CONSULTEE RESPONSE (Arun District Council - Arboriculturist)

Reference: LU/193/25/PL

Proposal: Proposed residential development for 4 houses and associated landscaping. This application may affect the setting of a Listed Building and is in CIL Zone 2 (CIL liable as new dwellings).

Location: Court Wick Park, Courtwick Lane, Littlehampton, BN17 7PD

Drainage Strategy
Sheet 1

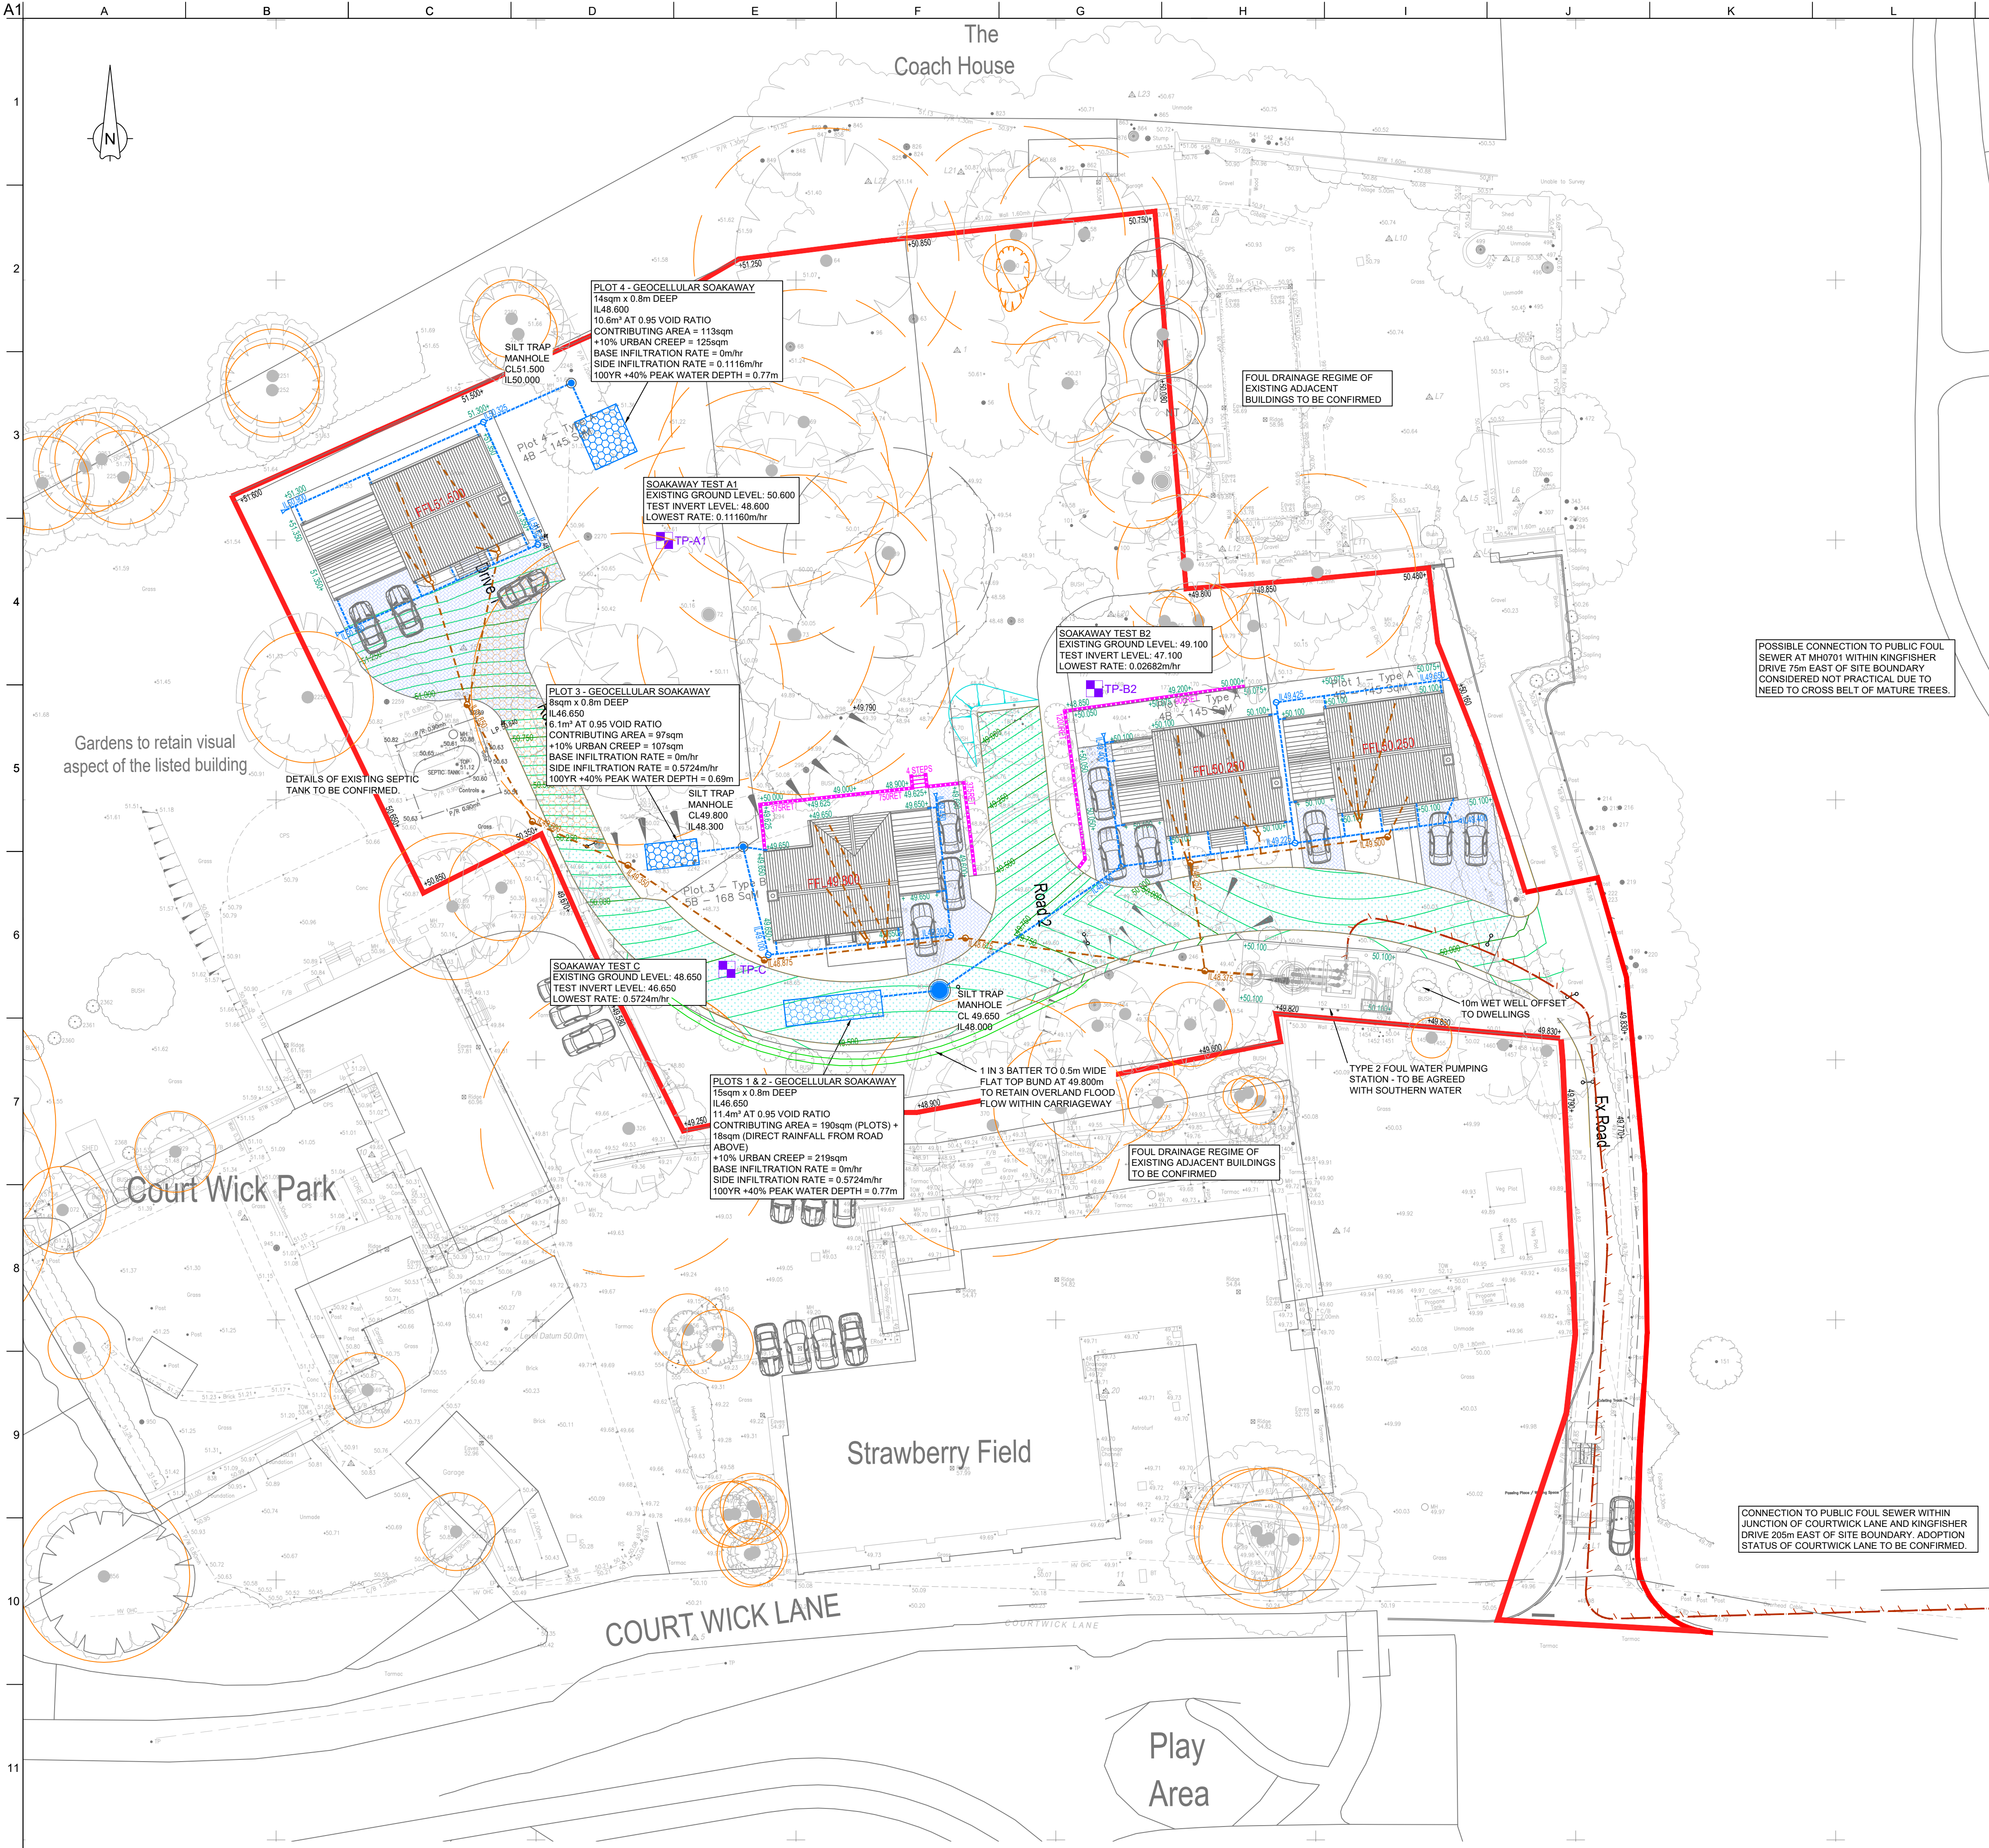
There does not appear to be an approved surface water drainage (and foul water sewer) strategy for the site. This fundamental element of the design ought to be addressed to our satisfaction in association with layout proposals, so that we are not subsequently held

hostage to flood mitigation measures which could then impact heavily on retained trees and landscape plans.

I draw attention to the nominal root protection areas (RPA) of retained trees and their growth potential as obvious constraints to the siting of any SUDS feature, soakaway or introduction of subterranean utility apparatus. The provision of appropriate buffer/easement around such features must also take into account that growth potential (roots), to limit the risk of damage occurring during future maintenance of the same, from compaction/contamination of the soil structure.
